Our Ref: R/2018/32/D
File No: 2020/06036

Response to Request for Additional Information – Adaptive Reuse of the Royal Hall of Industries (SSD-9726)

Thank you for your correspondence dated 4 February 2020 requesting for the City of Sydney Council (“the City”) to comment on the applicant’s response to the DPIE’s Request for Information dated 16 December 2020 for the adaptive reuse of the Royal Hall of Industries (RHI).

Figure 5.1: Loading dock and access arrangements

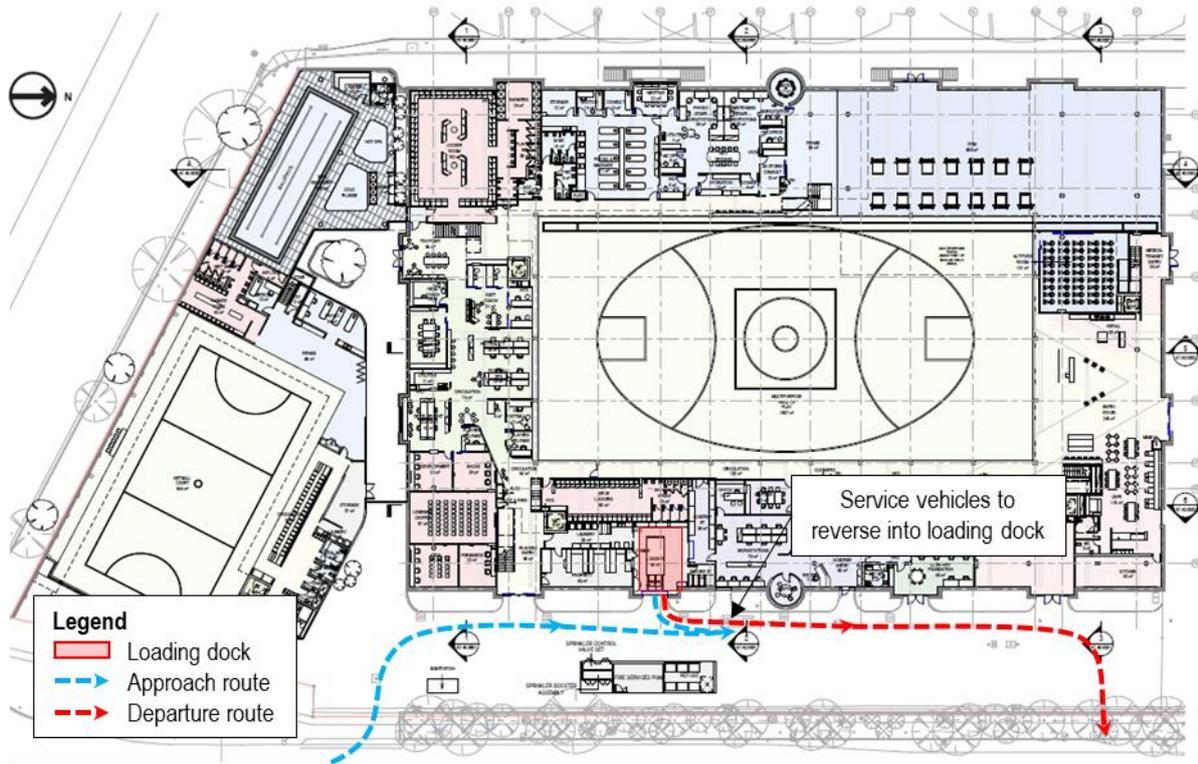
The Response letter has confirmed that 9 on-site parking spaces, including 1 accessible parking space, will be provided within the site. This is 2 less than the earlier proposal and is supported. It should be noted that the submitted swept path analysis is made on an older architectural plan. The revised swept path does not demonstrate unacceptable parking manoeuvring for the 8.8m MRV size vehicle and provides no indication of where this 8.8m MRV will park for loading and unloading. The revised GTA traffic report has confirmed that the site requires the access and egress arrangements for 8.8m MRV, 6.4m waste vehicle and 7.0m long minibus. Therefore, separate swept path analysis for the three types of service vehicles (8.8 m MRV including vertical clearance of 4.5 m, 6.4m waste and servicing truck and 7.0m minibus) including parking manoeuvring are to be submitted.

Figure 27 | Proposed and alternative crossover location shown in relation to the EQ car park access (Base source: Nearmap)

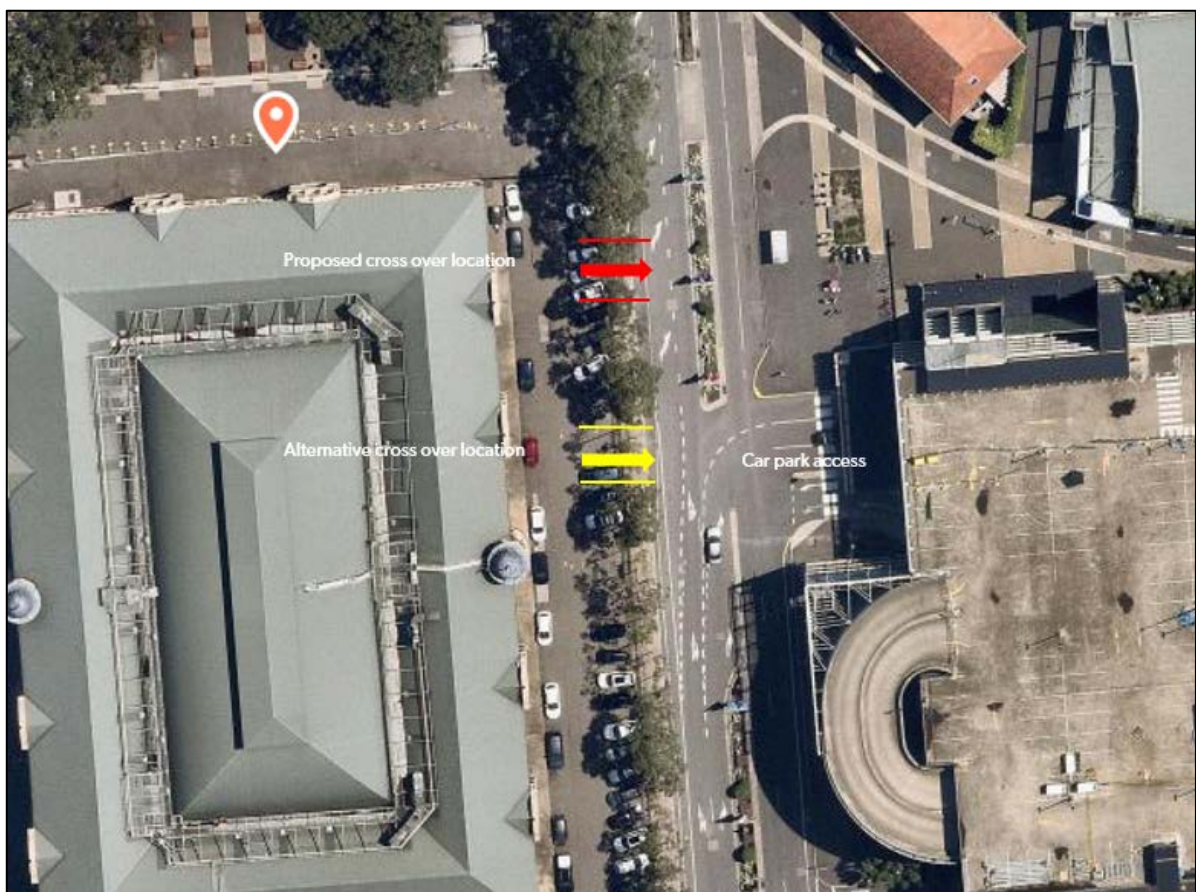
Whilst the majority of the tree removal is necessary, it is disappointing that no greater attempt was made to retain Trees 58, 59 and 60. The City maintains the view that the trees should be retained. It is reiterated that the proposed north-eastern driveway crossover be amended to utilise the existing driveway crossovers, or be relocated to remove a section of trees with a lesser value, size and health such as between trees numbered 42 to 46, and only removing trees numbered 43-45. Notwithstanding the above, the issue of tree removal is subject to the satisfaction of the DPIE as the consent authority.
